Application Ref:	3/2025/0300			 Ribble Valley Borough Council www.ribblevalley.gov.uk
Date Inspected:	28/05/2025	Site Notice:	28/05/2025	
Officer:	MC			
DELEGATED ITEM FILE REPORT:				APPROVAL

Development Description:	Proposed replacement windows, additional velux windows, alterations to window opening to form new door, provision of pigeon hole vents to gable wall. Glazed link to and conversion of garage to art studio, infilling of door and replacement of vehicular door. Installation of Air Source Heat Pumps and acoustic/absorbative screening.
Site Address/Location:	The Barn, Preston Road, Longridge, PR3 3BL

Planning Application
Proposed Site Plan

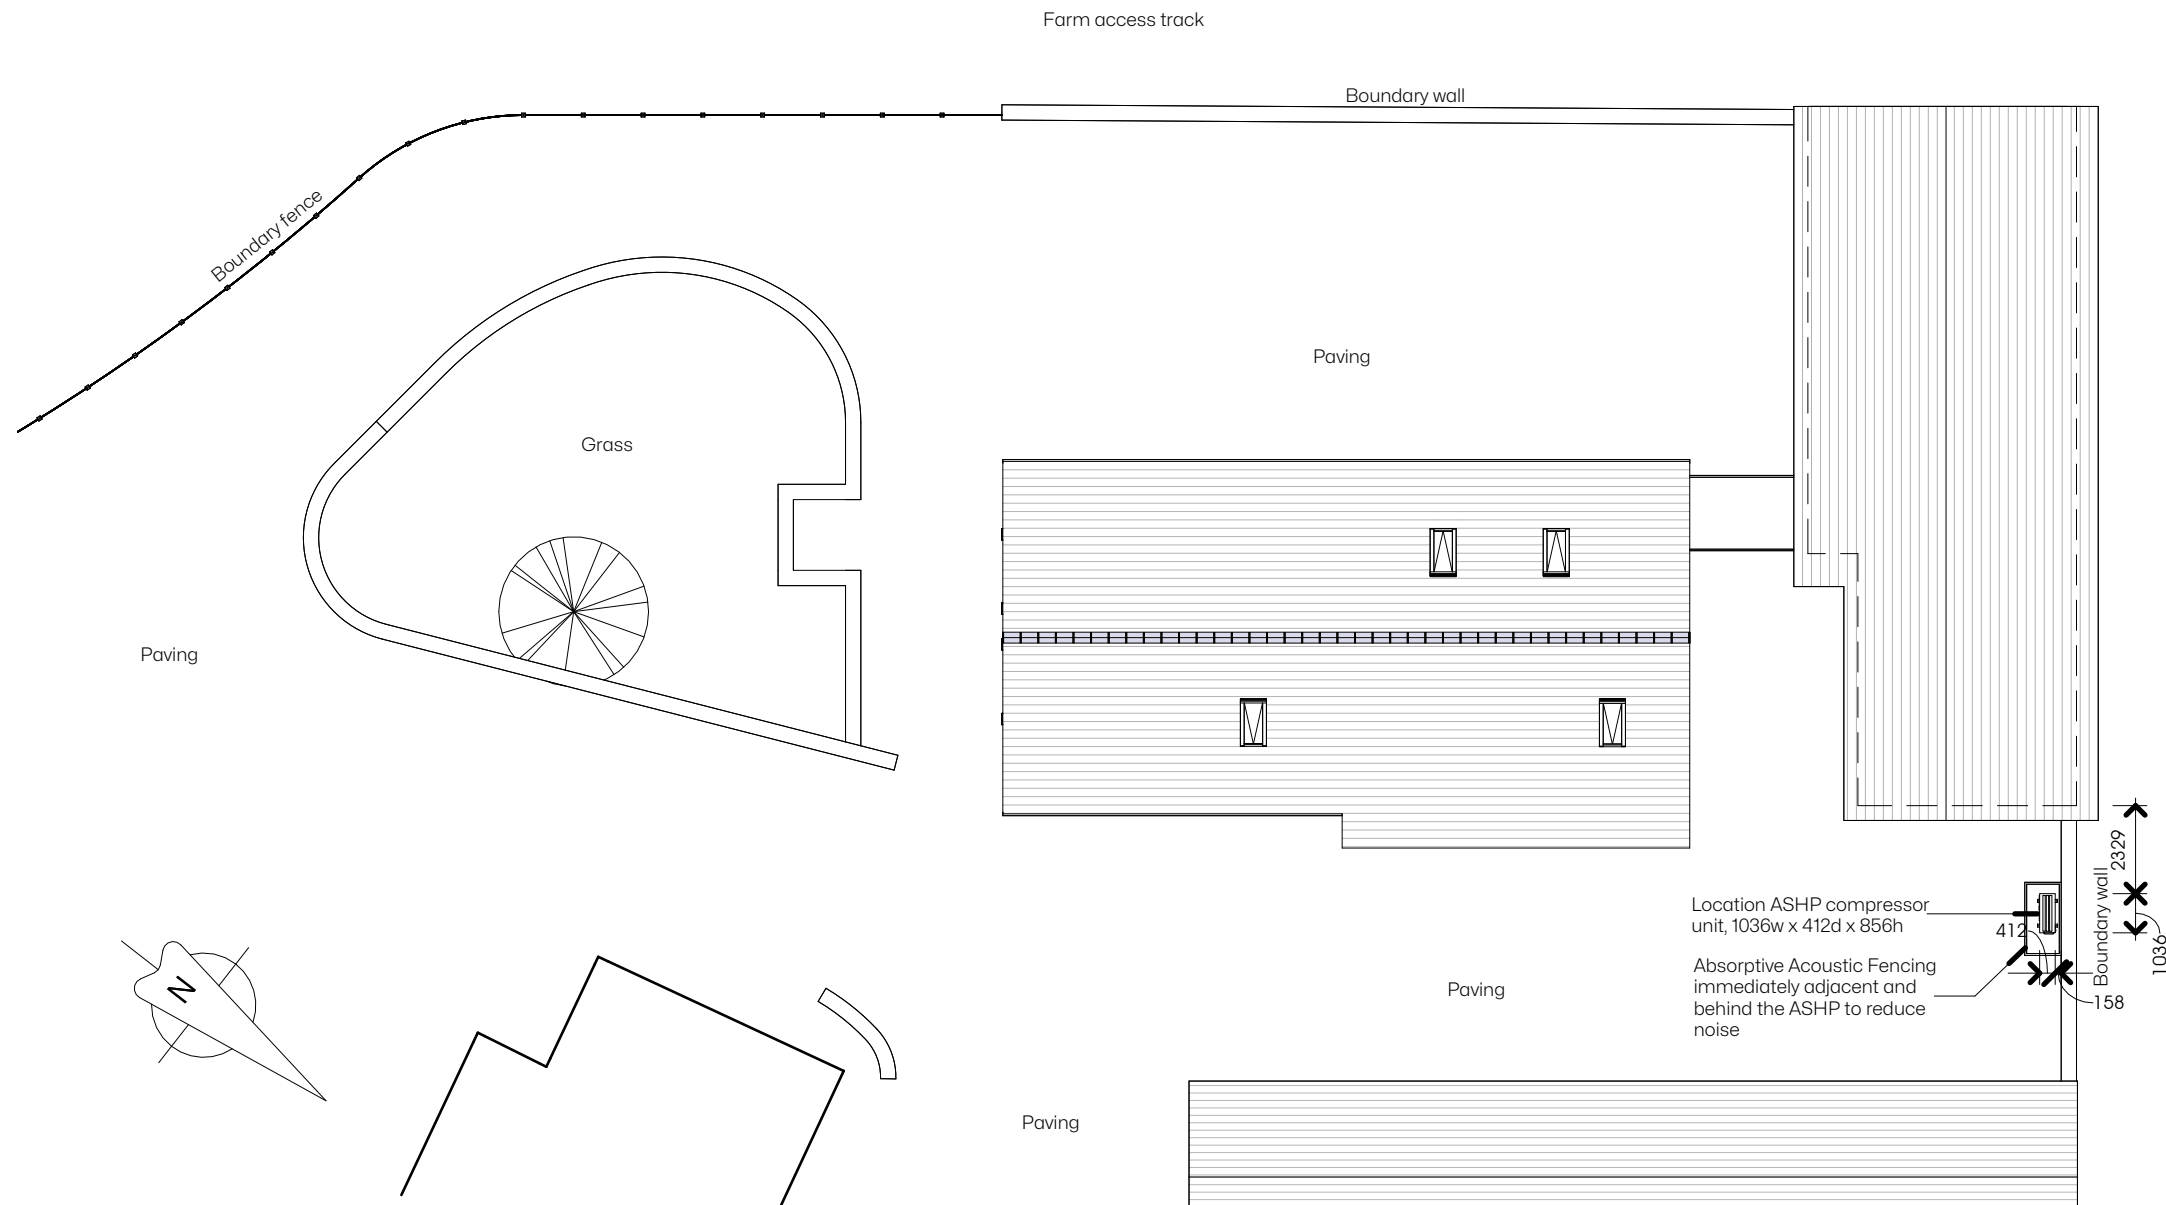
It is noted that the existing windows are not original features and therefore the change from uPVC windows to timber is considered an improvement and would be more appropriate to the character of the barn, subject to a condition securing their colour. The proposed rooflights have been reduced so that there are now 2 no.

Planning Application
Proposed Elevations 2

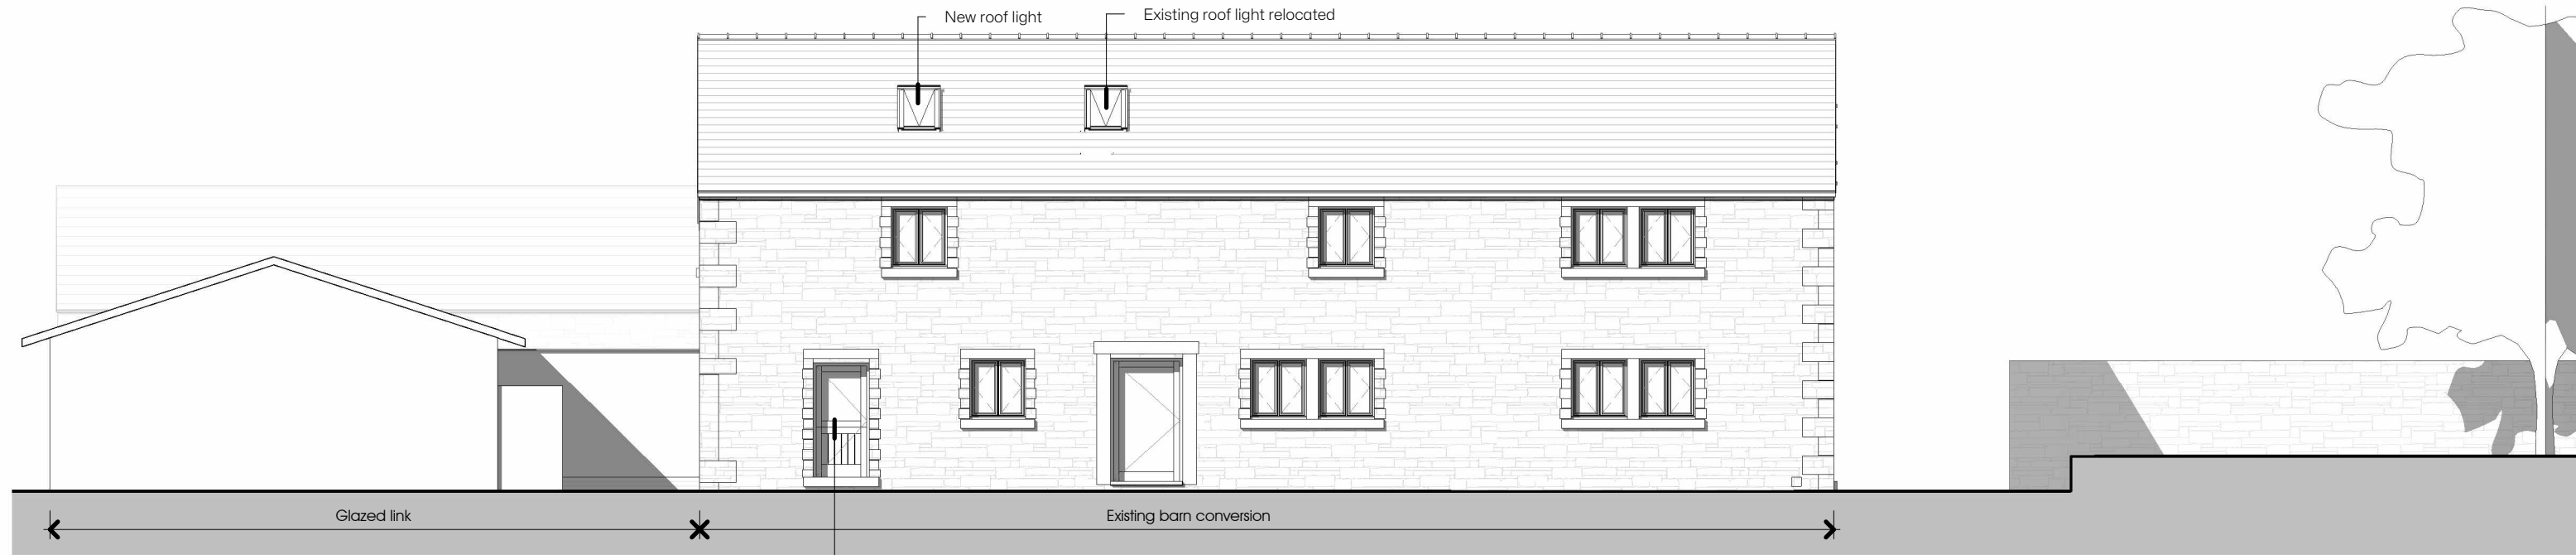
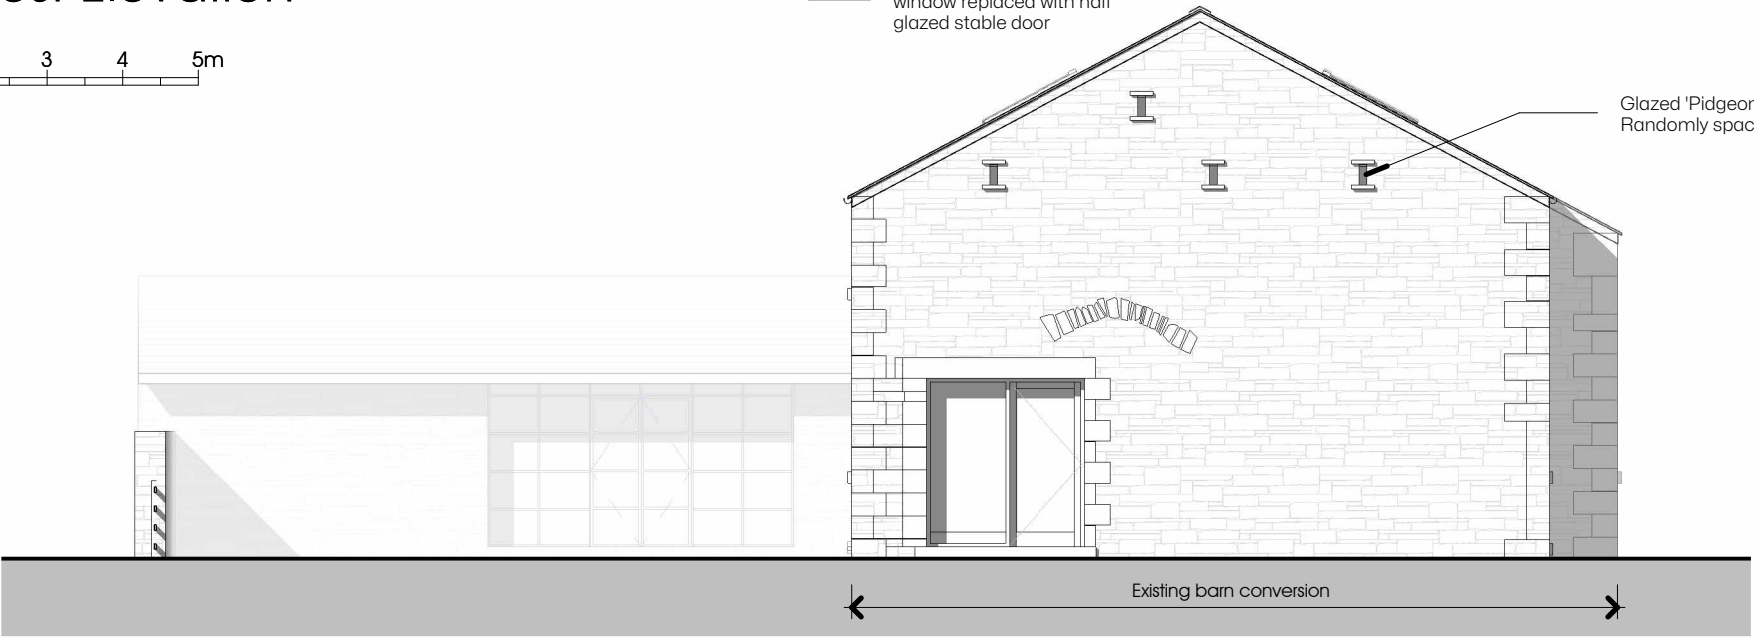
The Environmental Health Officer had originally raised concerns regarding the potential noise impact from the Air Source Heat Pump which is located adjacent to the property known as ‘The Stables’. As such, an acoustic/absorptive screen has now been provided adjacent to the proposed ASHP which is considered to provide sufficient mitigation to reduce any adverse noise impact resulting from the unit.

The drawings have been amended to reduce the number of rooflights, remove the proposed ‘picture’ window, replace one of the windows with a stable door and include an acoustic screen around the proposed Air Source Heat Pump.
